May 26th, 2026

El Paso County - Department of Public Works

**RE: STERLING RANCH FILING NO. 2 (SF20-15) – VOLUME CERTIFICATION LETTER FOR FULL SPECTRUM
DETENTION PONDS W4 & W5**

POND W-4 FULL SPECTRUM DETENTION BASIN DATA

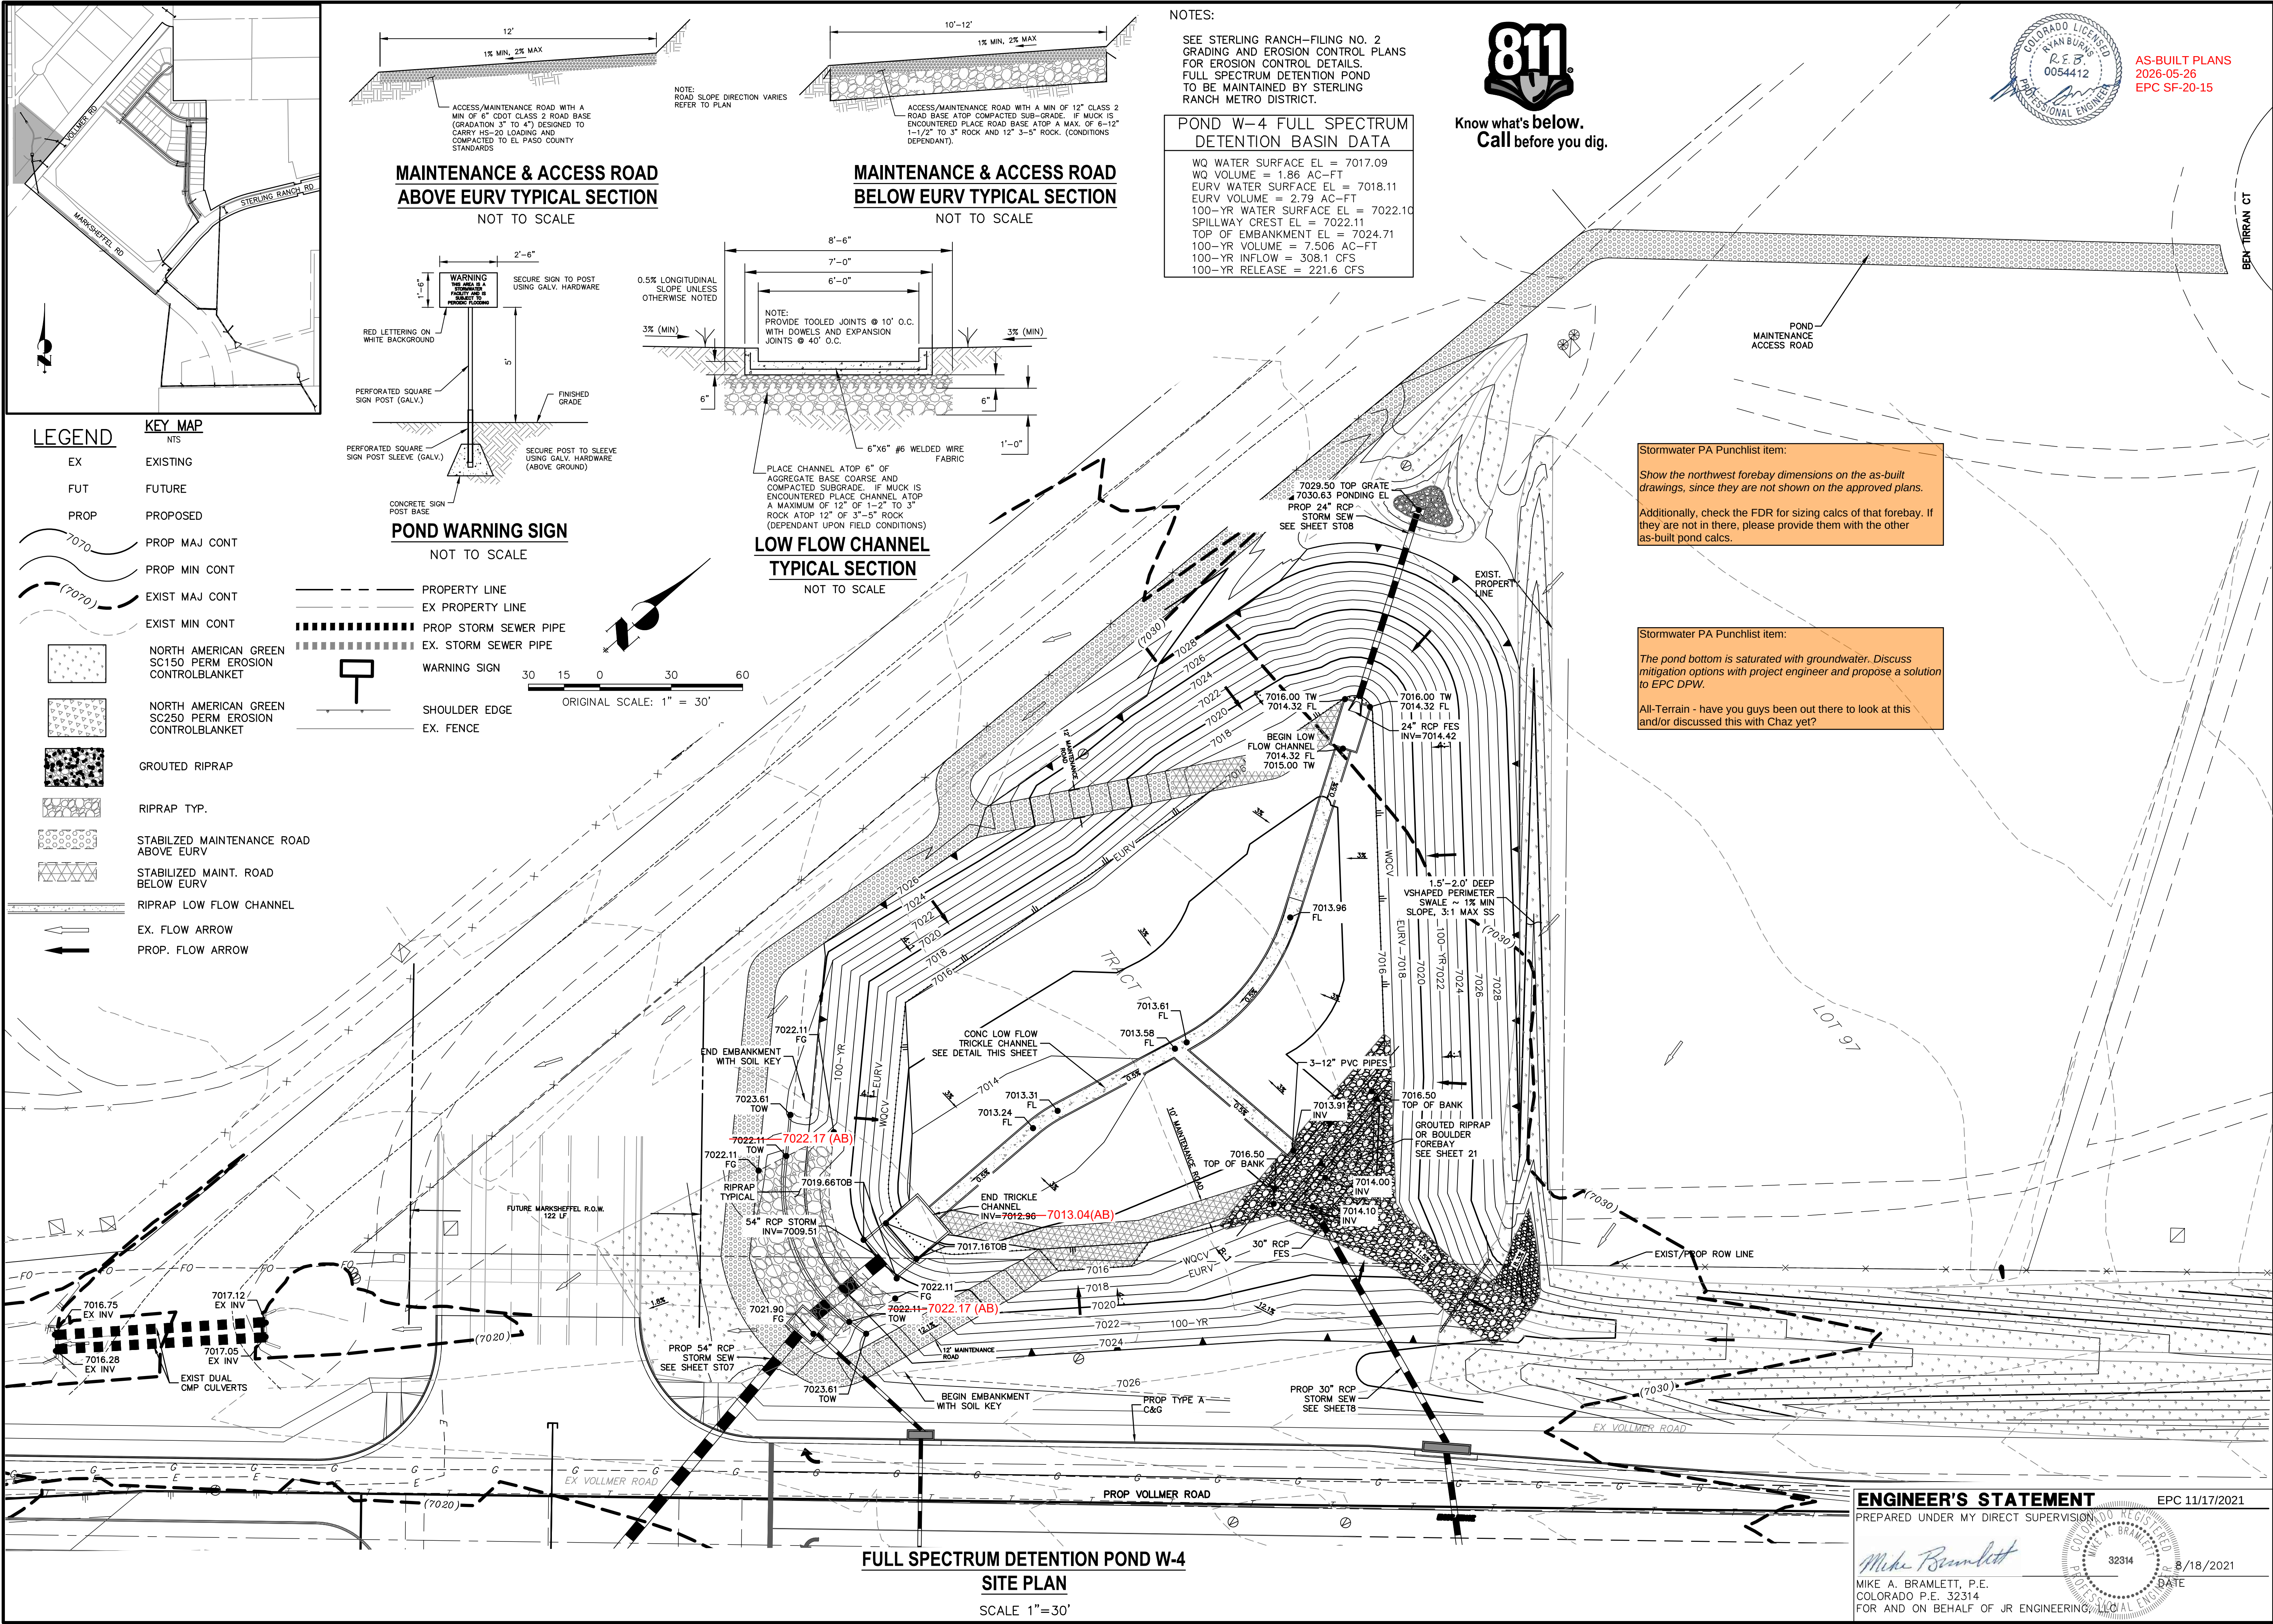
Zone 3 Weir	Not Selected
Overflow Weir Front Edge Height, H _o =	X 5.03	N/A
Overflow Weir Front Edge Length =	X 19.50	N/A
Overflow Weir Grate Slope =	X 4.70	N/A
Horiz. Length of Weir Sides =	10.00	N/A
Overflow Grate Type =	Type C Grate	N/A
Debris Clogging % =	50%	N/A

Zone 3 Restrictor	Not Selected
Depth to Invert of Outlet Pipe =	X 2.52	N/A
Outlet Pipe Diameter =	X 54.00	N/A
Restrictor Plate Height Above Pipe Invert =	X 54.00	N/A

Spillway Invert Stage =	X 10.00	ft (relative to basin bottom at Stage = 0 ft)
Spillway Crest Length =	X 75.00	feet
Spillway End Slopes =	X 5.00	H:V
Freeboard above Max Water Surface =	X 0.67	feet

as-built this on the plans

STORM 23 - 84" OUTFALL STILLING BASIN W/ HEADWALL & WINGWALL
SCALE: 1" = 4'

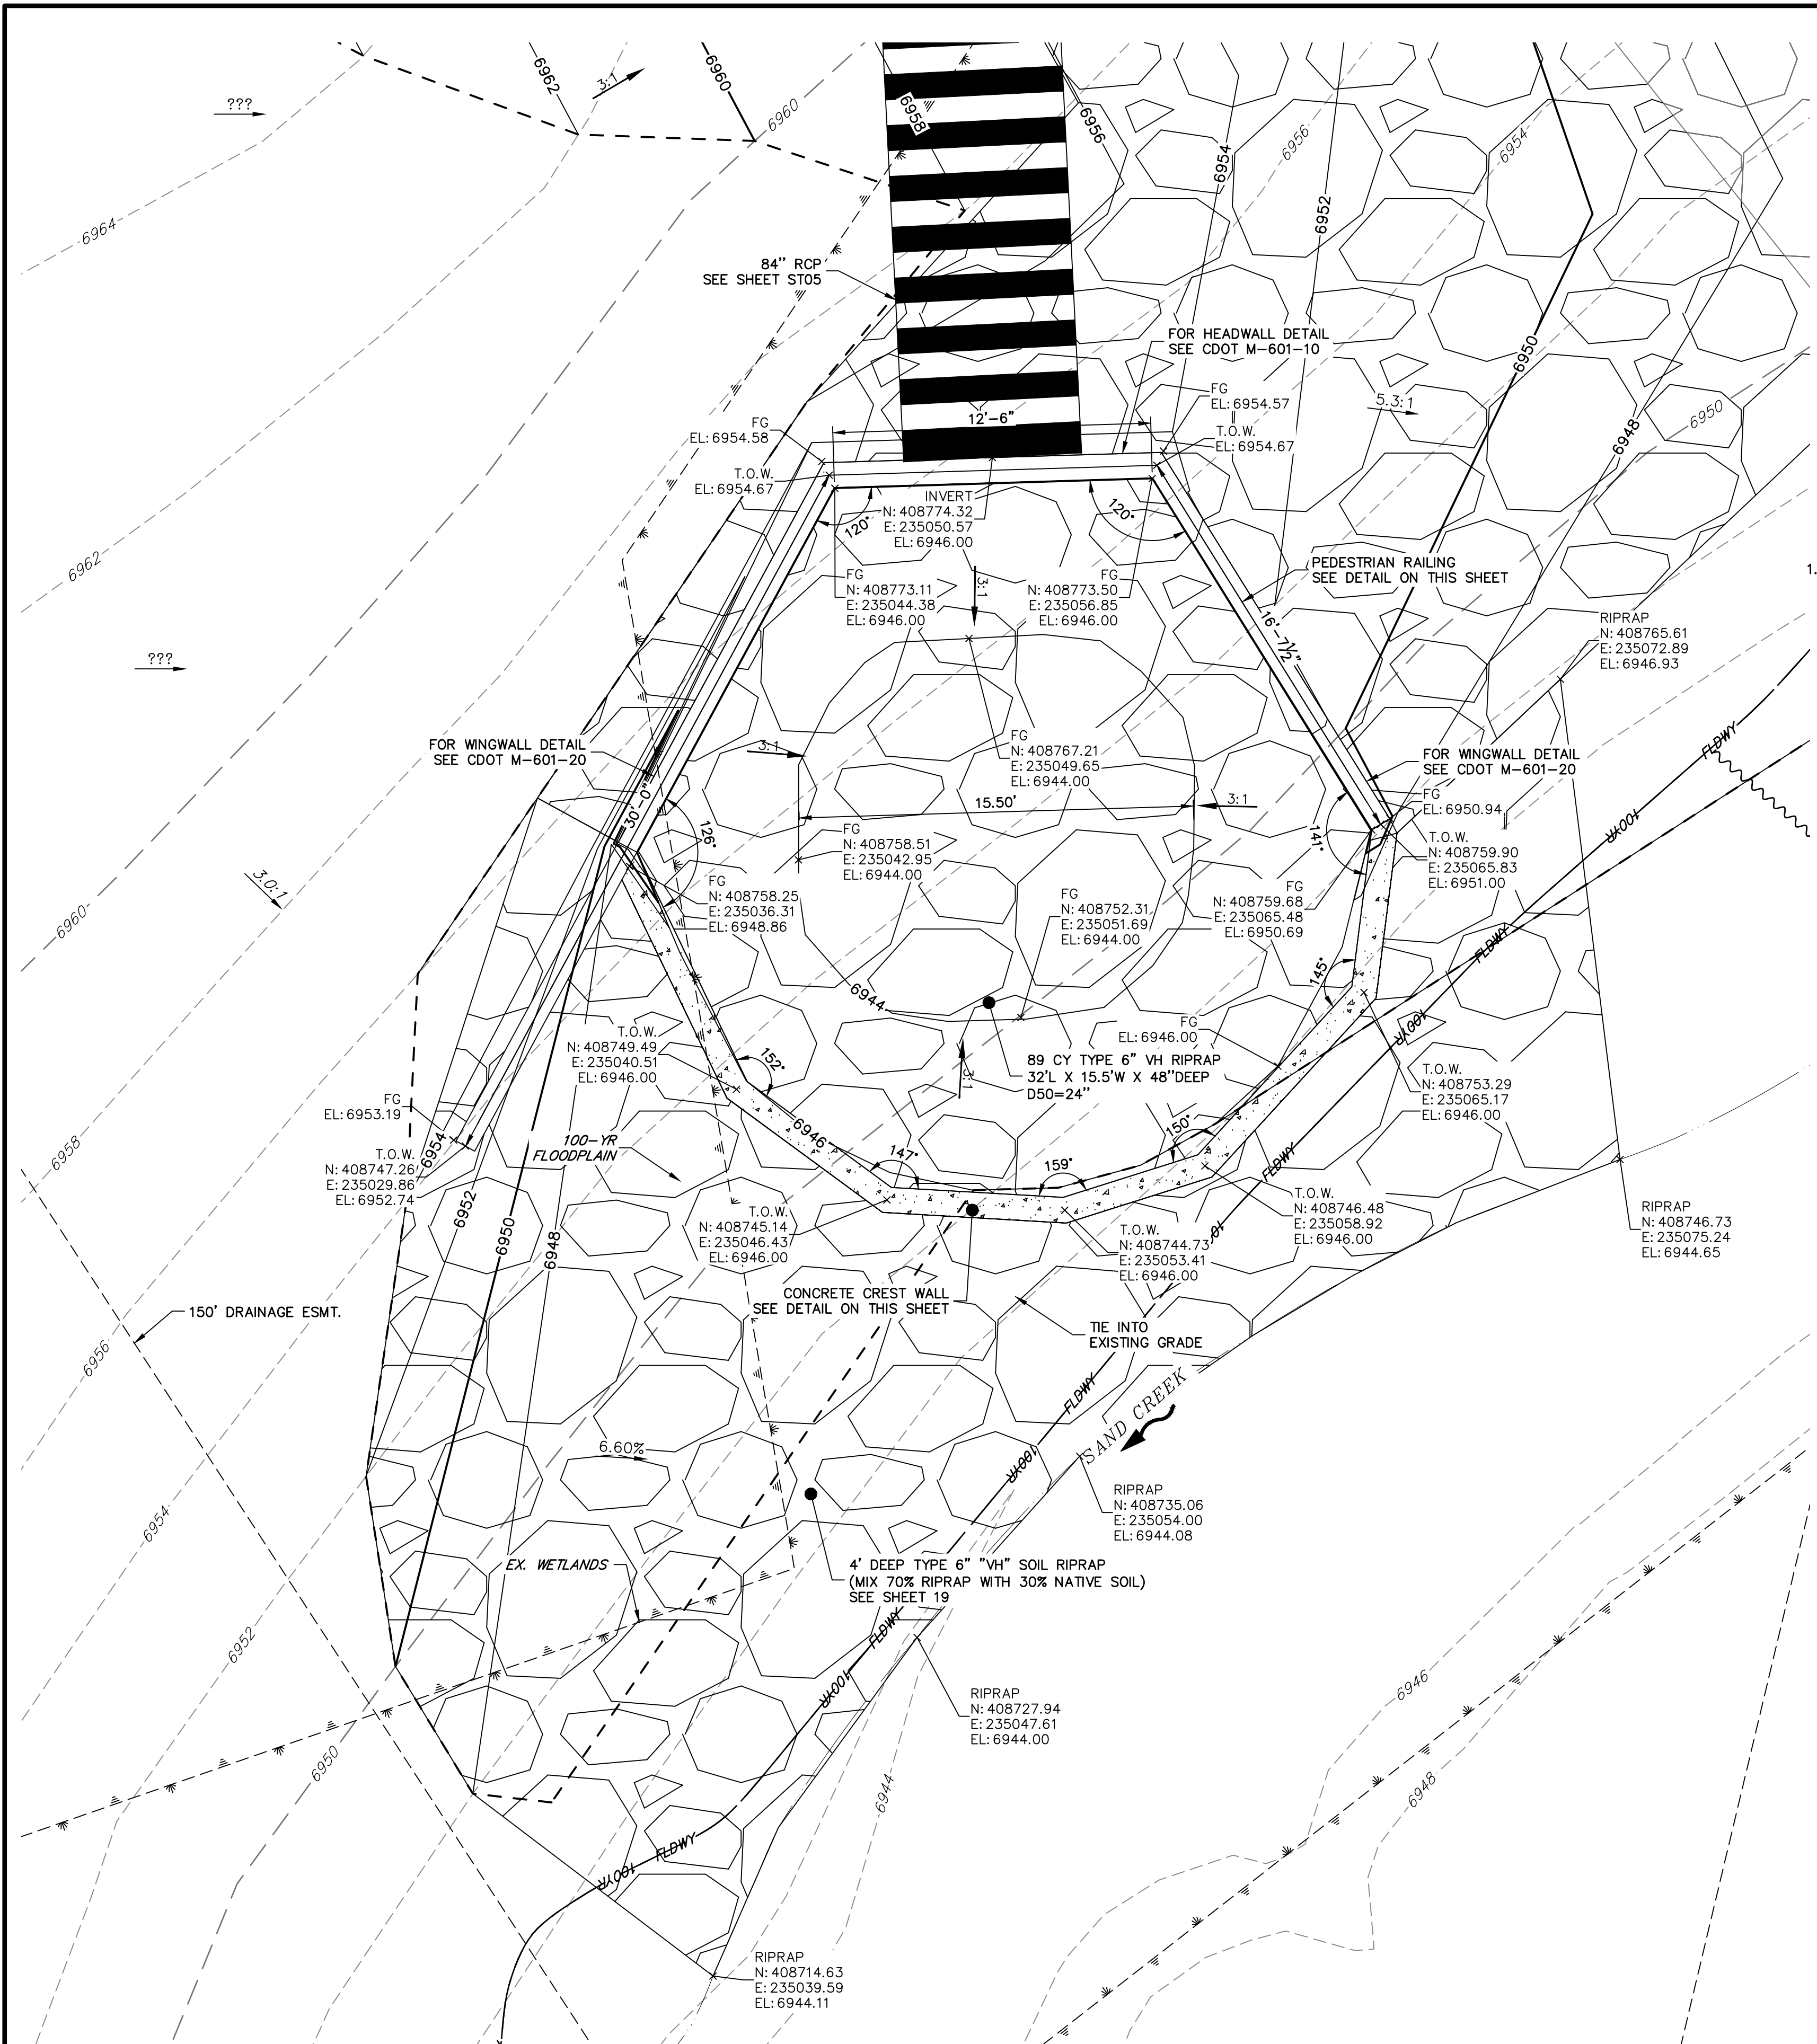
Row 1 (required)	Row 2 (optional)	Row 3 (optional)	Row 4 (optional)	Row 5 (optional)	Row 6 (optional)	Row 7 (optional)	Row 8 (optional)
Stage of Orifice Centroid (ft)	✓ 0.10	✓ 2.25	✗ 4.20					
Orifice Area (sq. inches)	✓ 8.13	✓ 12.50	✓ 25.00

Zone 3 Weir	Not Selected	
Overflow Weir Front Edge Height, H _o =	✓ 7.90	N/A	ft (relative to basin bottom at Stage = 0 ft)
Overflow Weir Front Edge Length =	✗ 20.00	N/A	feet
Overflow Weir Grate Slope =	✓ 0.00	N/A	H:V
Horiz. Length of Weir Sides =	✗ 6.50	N/A	feet
Overflow Grate Type =	Type C Grate	N/A	
Debris Clogging % =	50%	N/A	%
